State of Washington  
DEPARTMENT OF FISH AND WILDLIFE

SUBJECT: WDFW COMMENTS ON CU-24-00001 Vantage Valley Properties

CROSS VALLEY
 NATIONAL TRAINING
 CENTER
 SITE PLAN
 OCTOBER 9, 2023

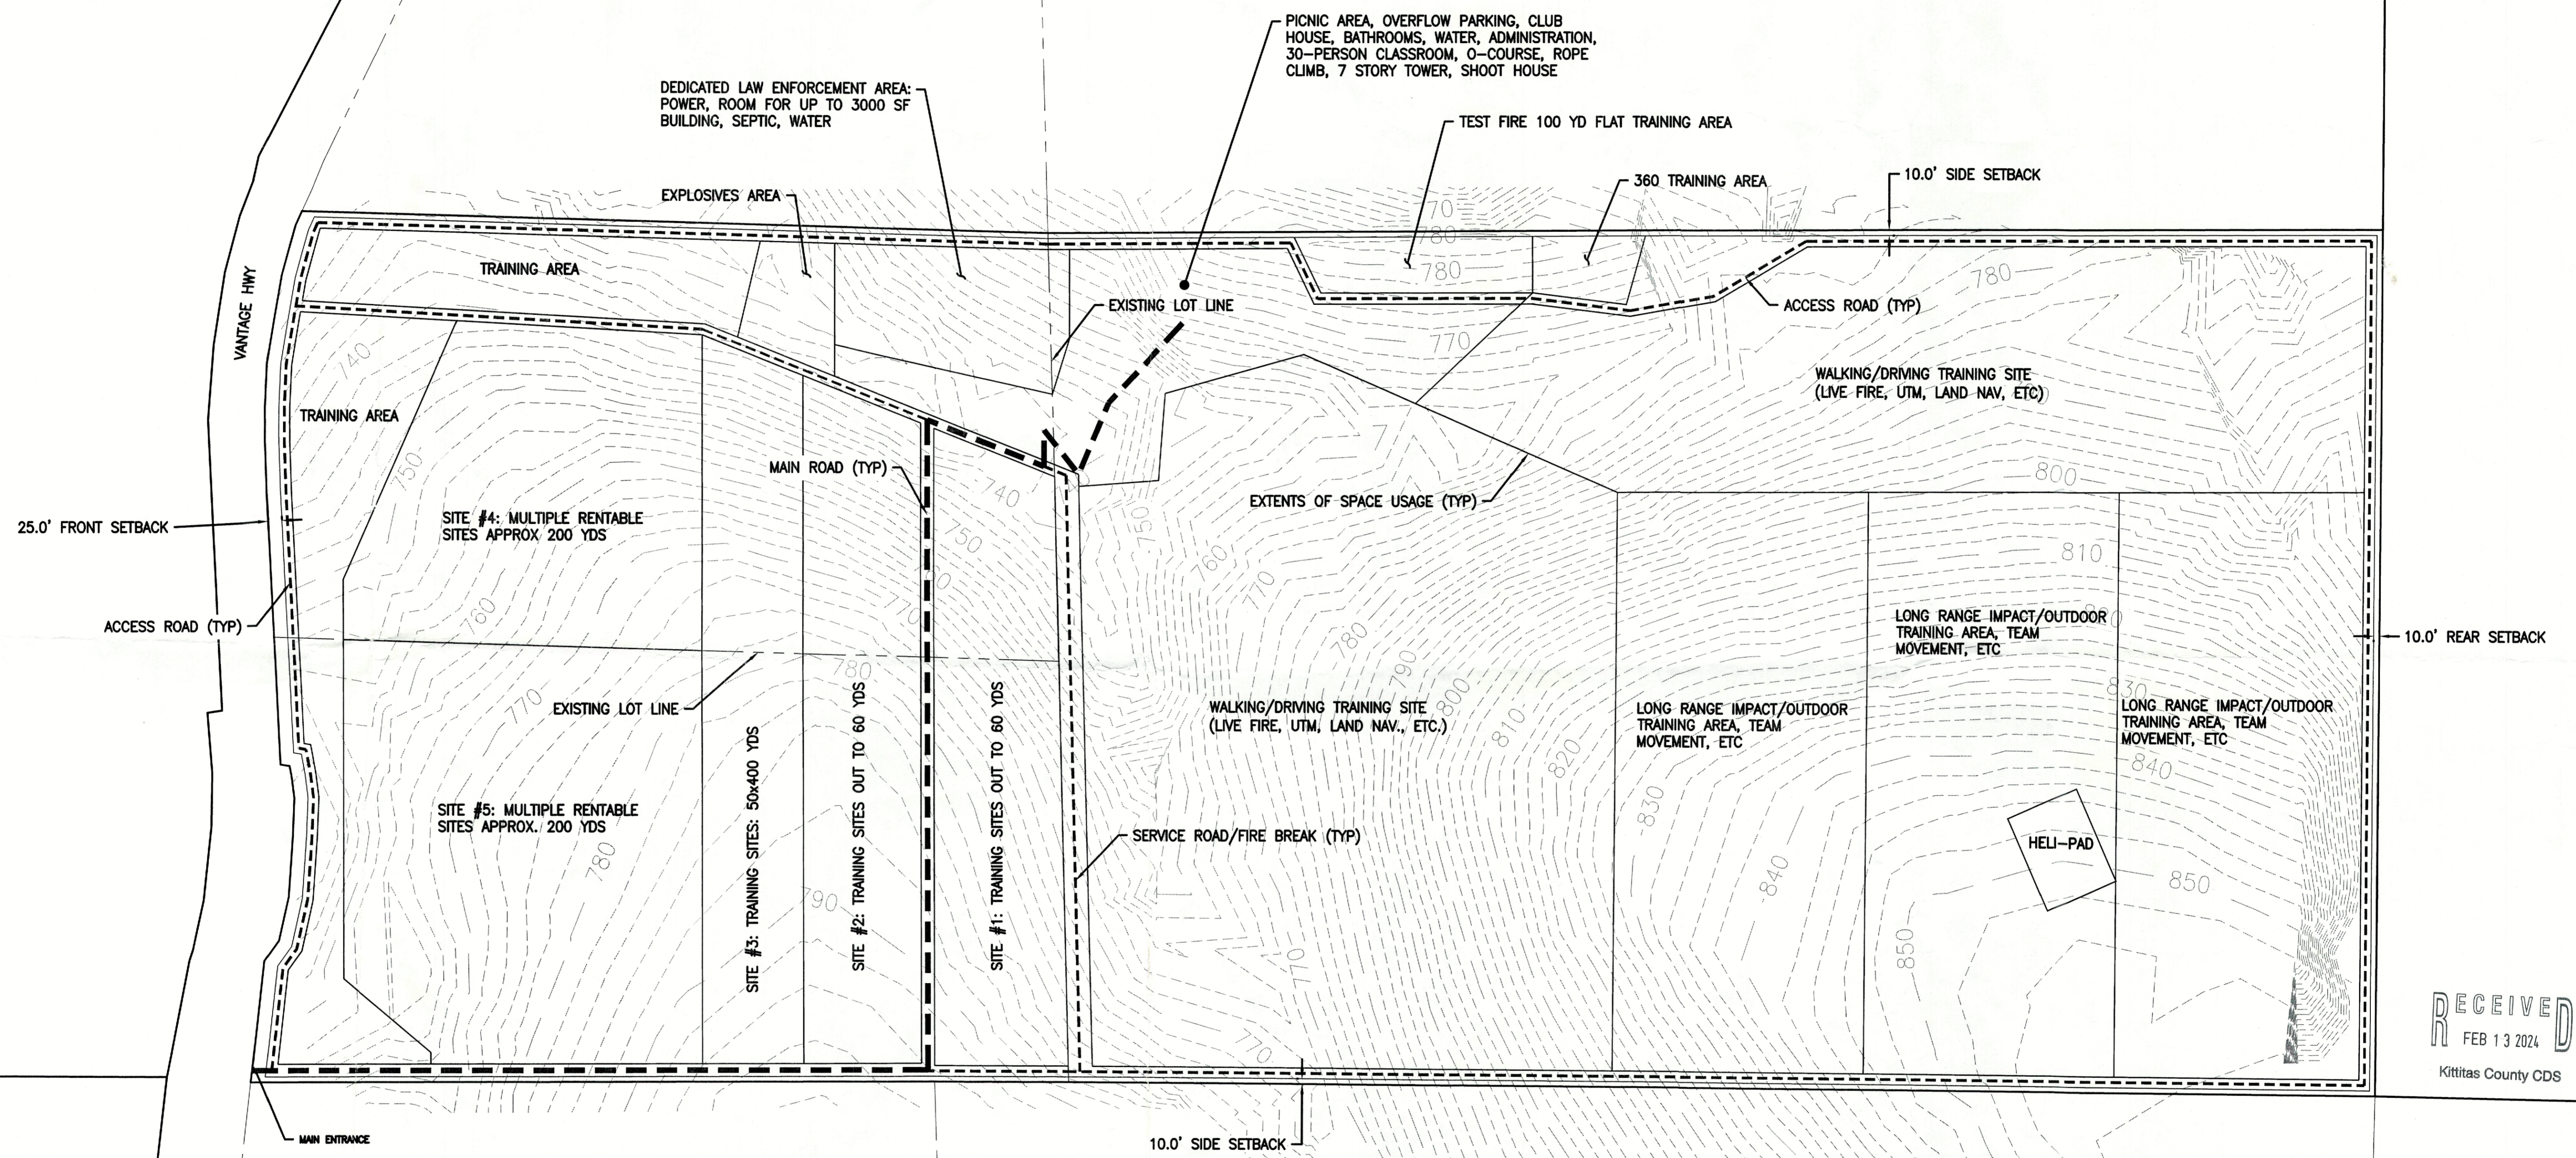
- As currently proposed, a minimum 10-foot setback from the western property boundary (which includes WDFW managed land) and proposals for explosives area, training areas, and test fires. Both wildlife and recreational visitors could be on either side of this boundary. The project needs to further demonstrate how these activities will not impact either the wildlife or the recreational users. The information currently provided in the SEPA checklist is incomplete to draw this conclusion. Potential modifications could include the need to increase the buffer distance from these activities (particularly in high-risk activities such as explosives), and the property line, add berms, and clearly mark the boundaries with proper warnings.

- In the northern portion of the site plan, a Heli-pad is proposed. As this area is a Mule Deer and Elk wintering area, consultation with WDFW is requested and proposed flight paths in and out of this Heli-pad need to be discussed to ensure the applicant is not displacing the animals away from vital winter forage, but also potentially displacing deer and elk into other properties or onto the Vantage Highway.

- Little detail is shown on the site plan, showing the direction of live fire, or proposed berms/backstops. Further the roads are shown as direct lines, yet the topography suggests that it will be difficult to construct due to the steepness of the grade. Please include WDFW in these discussions as the site plan and its associated impacts develop.

- We understand that based upon the current site plan, that the current access through WDFW lands would no longer be necessary. Coordination with WDFW on the management of that road going forward is vital, including signage and fencing to keep the public accessing this site from unauthorized vehicle entry onto adjacent lands.

Map 1. Parcel overview with DNR water type and wetland layers.

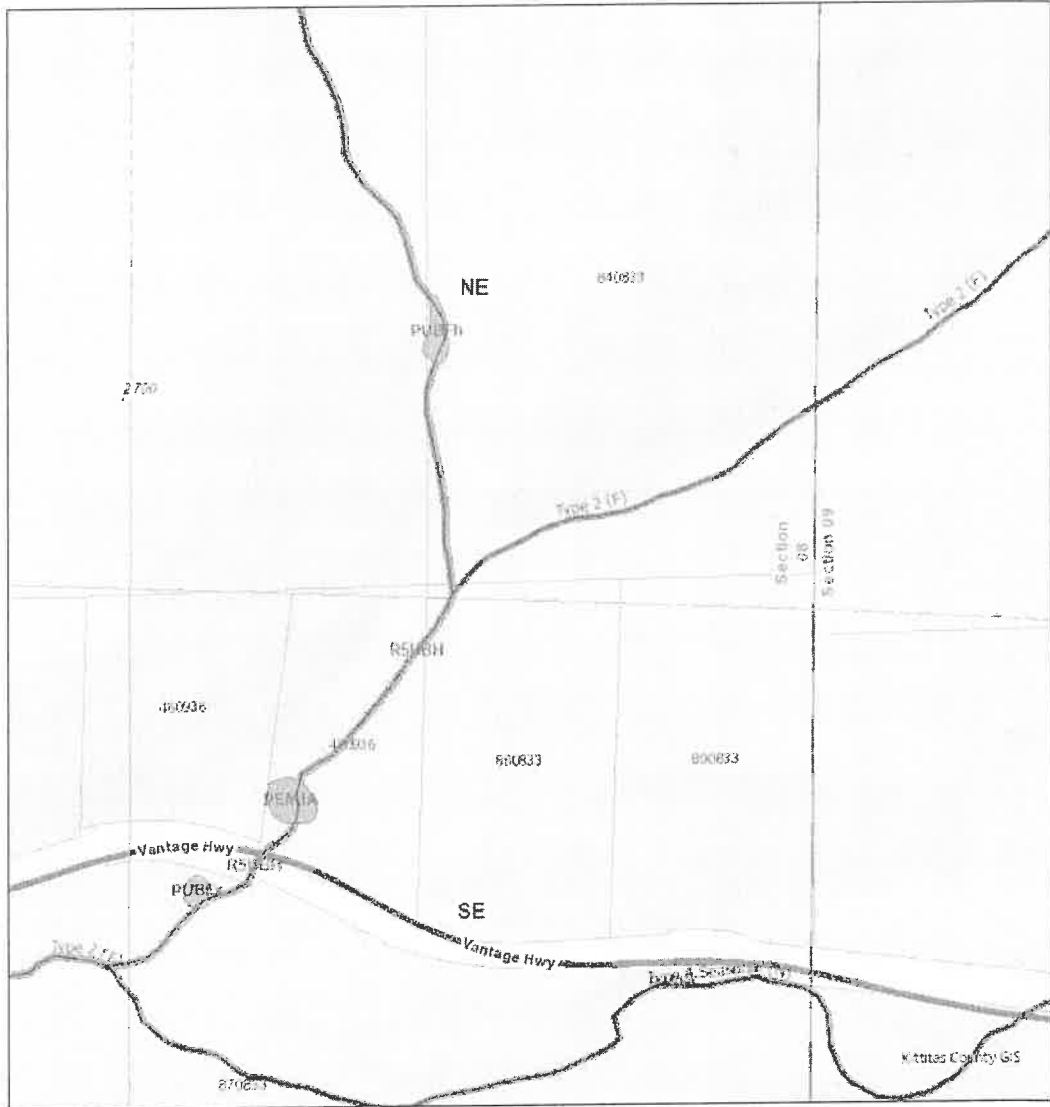
There is a stream listed on the map, with a designation of a fish-bearing stream. While we note that the memorandum included in the application stated that the stream did not meet the definition of either a fish-bearing stream or a stream in general, WDFW would like to comment that the memorandum definition of a Type F stream or a stream in general is not consistent with current stream typing definitions. A Type F stream for Eastern WA has a bankfull width average of 3 feet or more, with a gradient of 16% or less. WDFW requests a site visit with Kittitas County and the applicant to verify the stream typing on the property to assist with determination of appropriate Riparian Management Zone (RMZ) setbacks under the CAO.
